Rezoning Transportation Analysis

Petition Number: Zoning Petition #2021-019

General Location Identifier: 14907304

REZONING SITE PLAN SCALE 1" = 60'

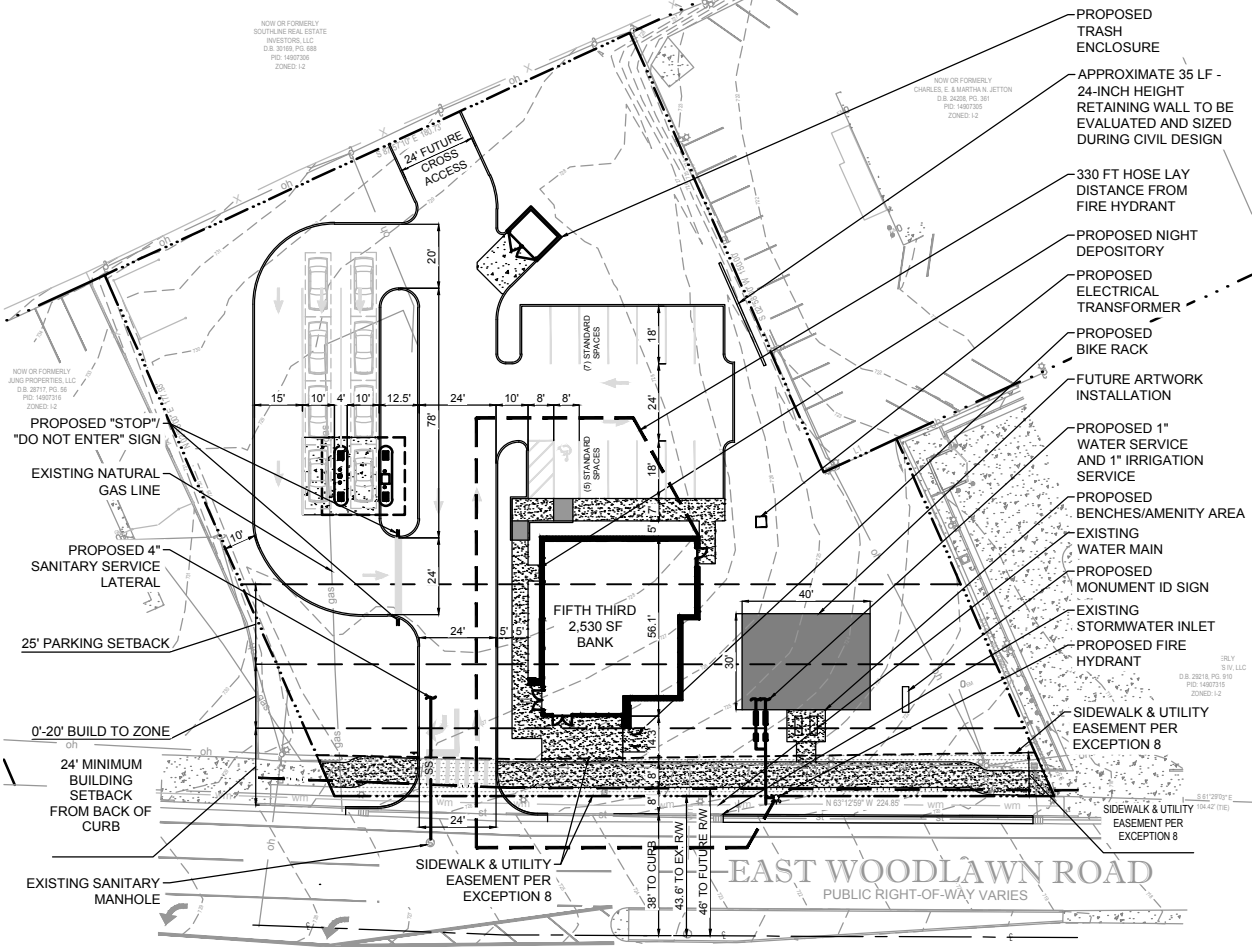
2. ~~Including a conditional note that the proposed site access, off Woodlawn Road, will be subject to NCDOT recommendations and approval, to be coordinated during the permitting process.~~

3. ~~A site plan note(s) specifying dedication and fee simple conveyance of all rights-of way to the City and/or NCDOT before the site's first building certificate of occupancy is issued is needed. CDOT requests rights-of way set at 2' behind back of sidewalk where feasible.~~

4. ~~A site plan note specifying that all transportation improvements will be approved and constructed before the site's first building certificate of occupancy is issued is needed. The petitioner may phase transportation improvements if said improvements and phasing are explicitly described in site plan notes.~~

5. ~~Revise the conditional notes by including the following note:~~

~~All public roadway improvements will be subject to the standards and criteria of CDOT and NCDOT, as applicable, to the roadway improvements within their respective road system authority. It is understood that such improvements may be undertaken by the Petitioner on it's own or in conjunction with other development or roadway projects taking place within the broad south Mecklenburg area, by way of private/public partnership efforts or other public sector project support.~~
